Engineers Comments Regarding Surface Water Drainage

Application Reference:	Y/32/25/PL	Reviewer Reference:	ADC/PC
Planning Officer:	Simon Davis	Date of Review:	20/08/2025
Site Name:	Land West of Bilsham Road Yapton BN18 0LA		
Application Description:	Erection of 170 No residential dwellings (30% affordable), parking spaces, internal site roads, public open space, childrens play space, pumping station, surface water drainage features, landscaping and associated works. This application is a Departure from the Development Plan and is in CIL Zone 3 and is CIL Liable as new dwellings.		
Assessment Number:	1 of 1

Scale	1:500 @A1	Date	APR 25	Designed	LG
Drawn	EW	Checked	LG	Approved	BAC
Job No	24-217	Drawing No	24-217-258	Rev	B

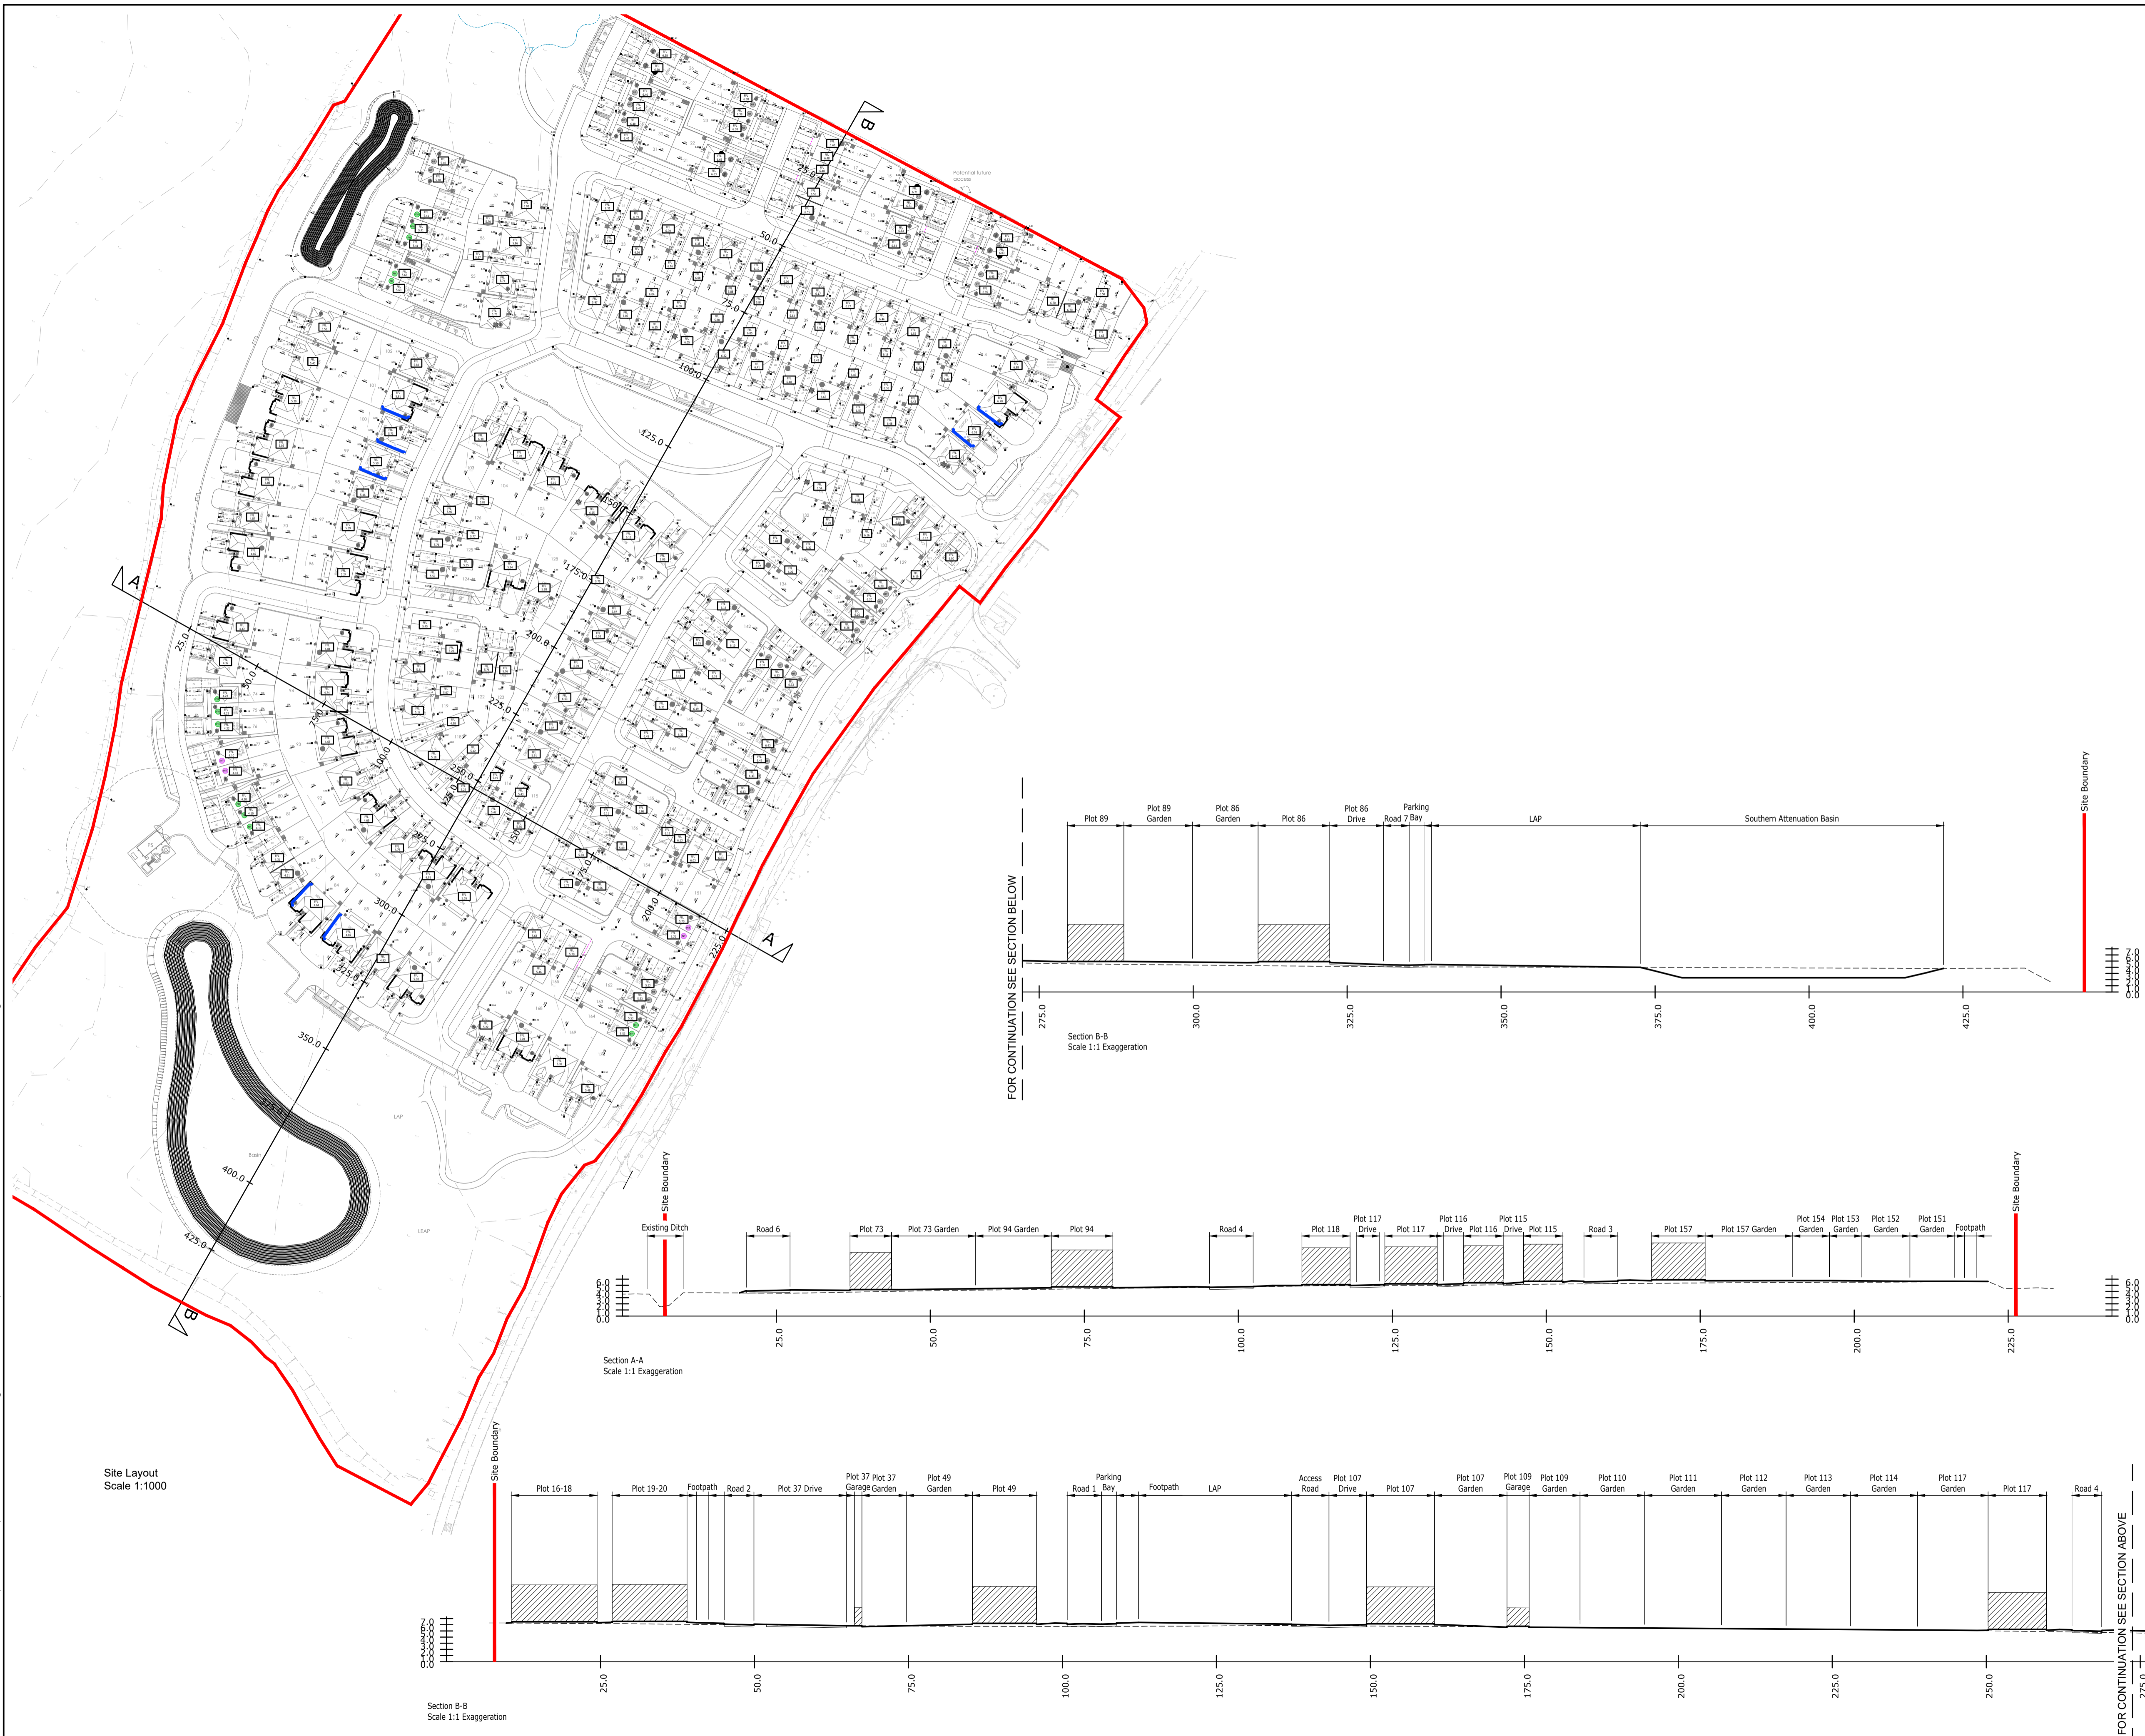
The model must consider surcharged outfalls at the two points of connection to the watercourse. The surcharge levels must be set to the peak water levels predicted in the watercourse by the known fluvial model outputs.
